Subject: FW: LU/49/20/DOC - Former Windroos Nursery, Worthing Road, Littlehampton, BN17 6LY - Stage of Development Discharge

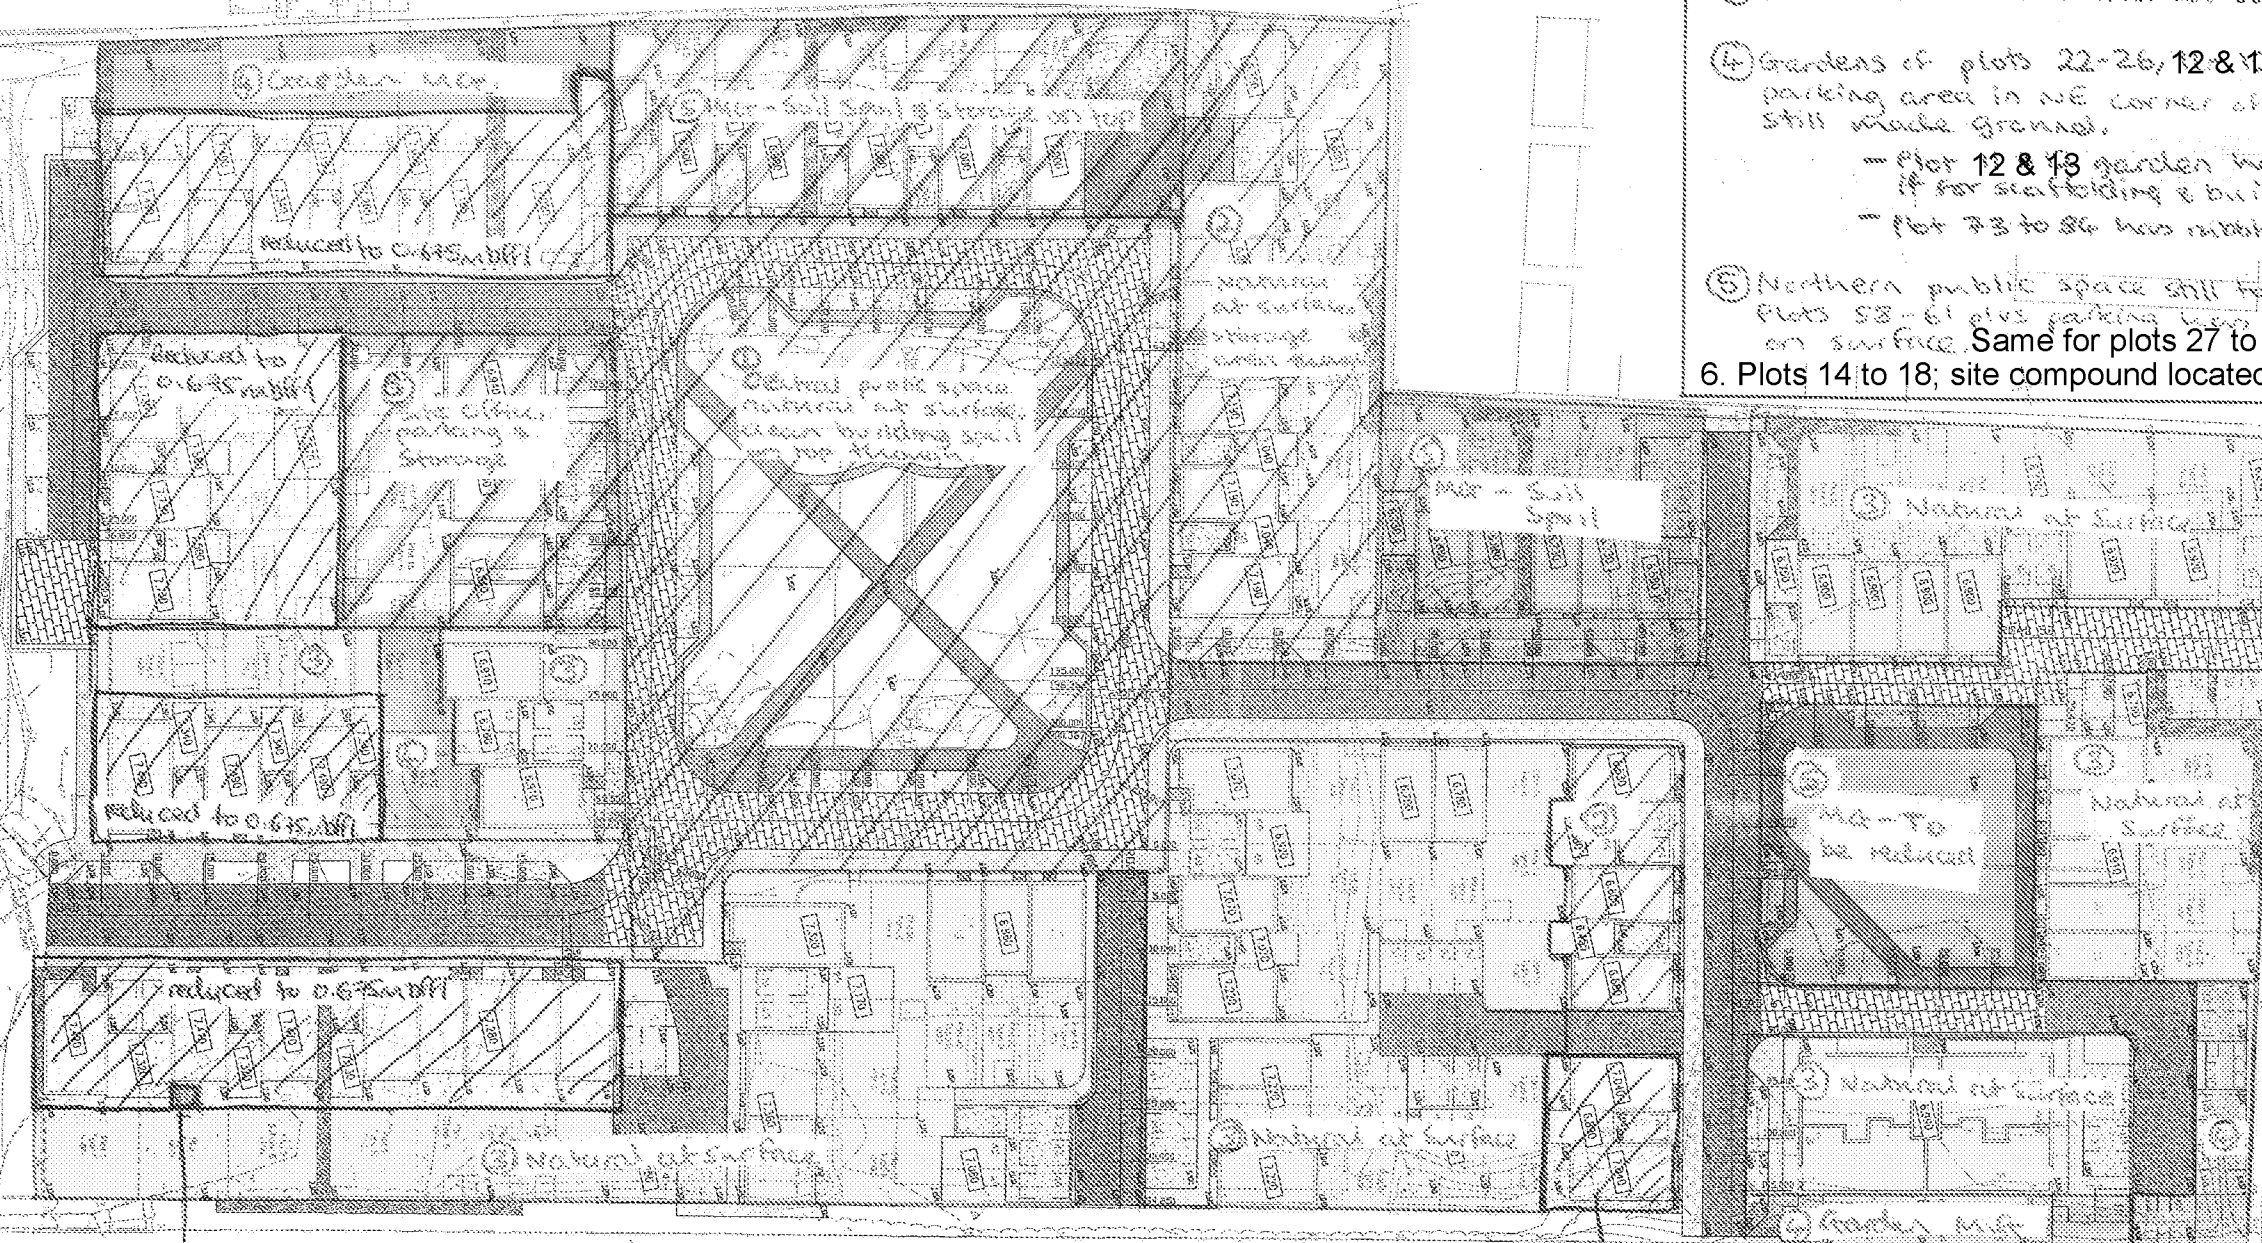
- validation visits to confirm appropriate installation of topsoil have yet to be conducted
- validation inspections of plots 14-18 are to be conducted
- validation inspections of the communal area to the north of the site are to be conducted
